From: Maria Tomalova <Maria.Tomalova@arun.gov.uk>
Sent: 26 October 2020 09:34
To: Planning.Responses <Planning.Responses@arun.gov.uk>
Subject: FW: BE/92/20/DOC

Environmental Health does not consider that the Drawing No. 871/PL02 Rev A constitutes a scheme for the control of dust from the site. It does not detail the sources of the dust, although it is assumed that the site access road is a source of dust. Therefore if there are further sources of dust other than the site access area, these have not been considered or mitigated.

DWG NO	871/PL02	REV. A
---------------	----------	---------------

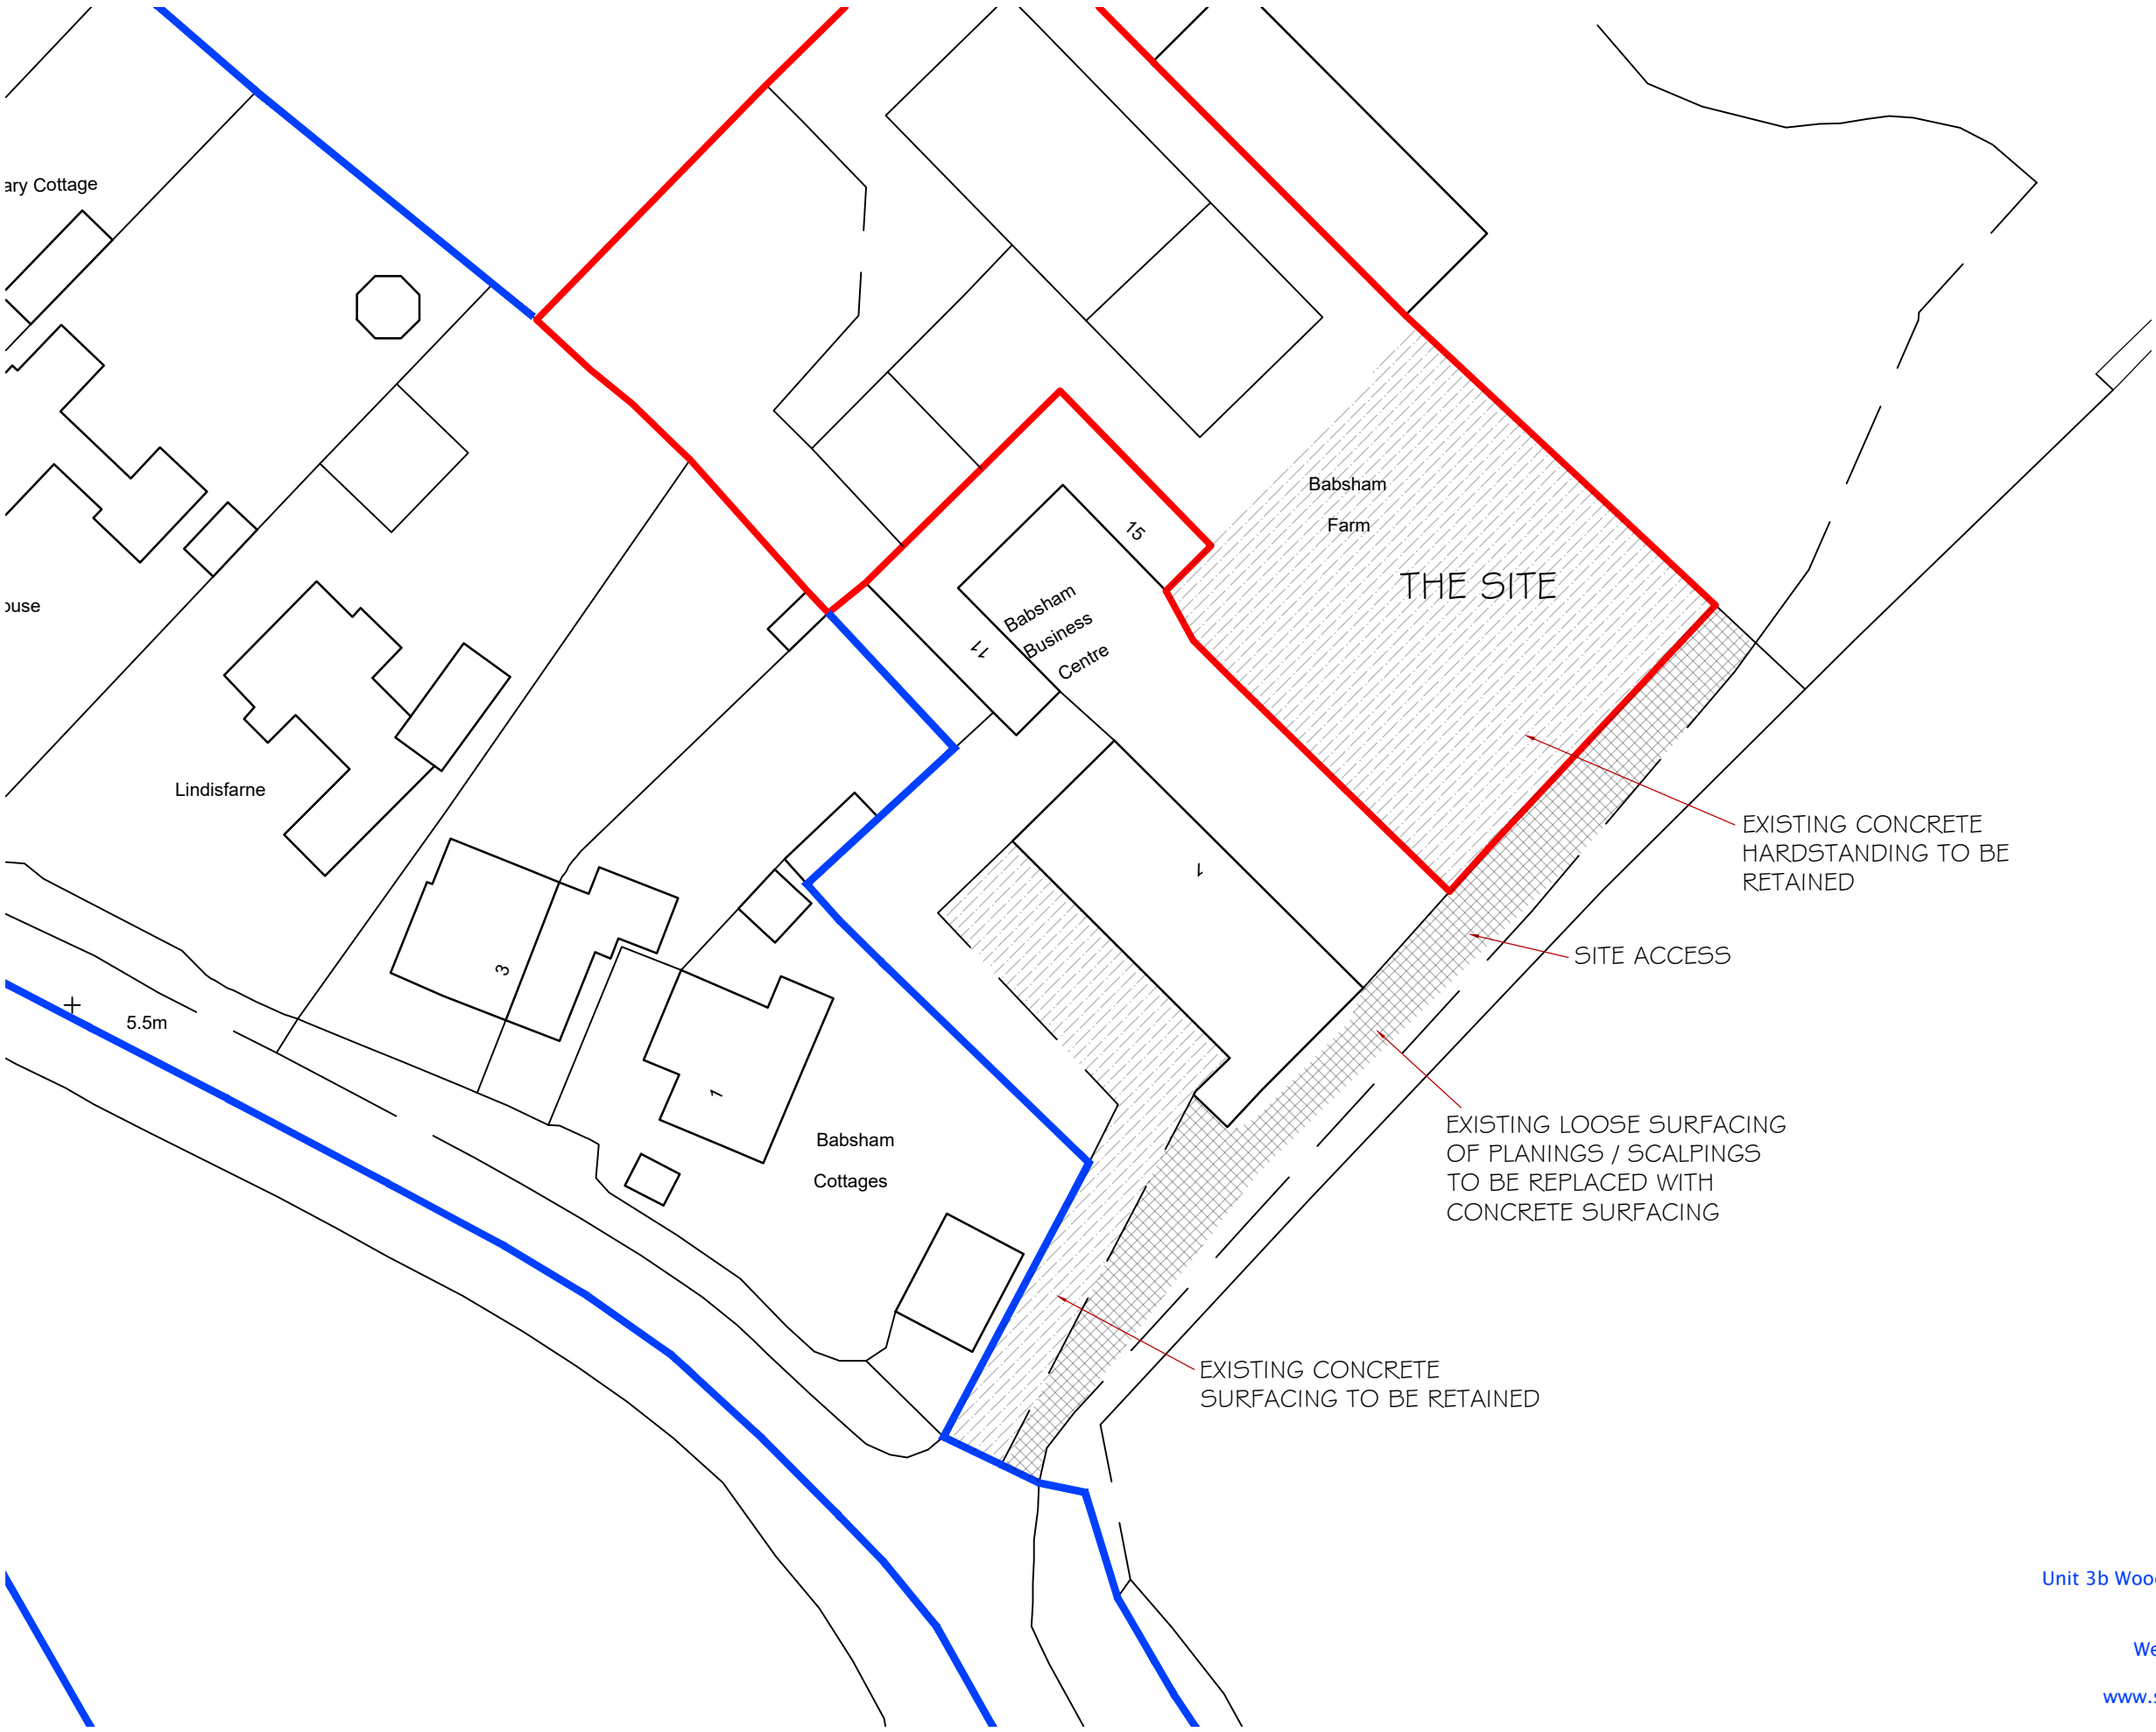
Please could the applicant confirm whether or not the site access road is the only source of dust expected, and if not, what the other sources are and how they will be controlled? Please could the applicant also advise whether muddy vehicles are likely to enter or exit the site and whether or not this is a source of dust that may need to be controlled by a wheelwasher or similar?

I can confirm that the only source of dust on the site is the existing un-made access drive. The resurfacing of this access drive will remove this source of dust. It is not envisaged that vehicles with particularly muddy wheels would be likely to enter or exit the site.
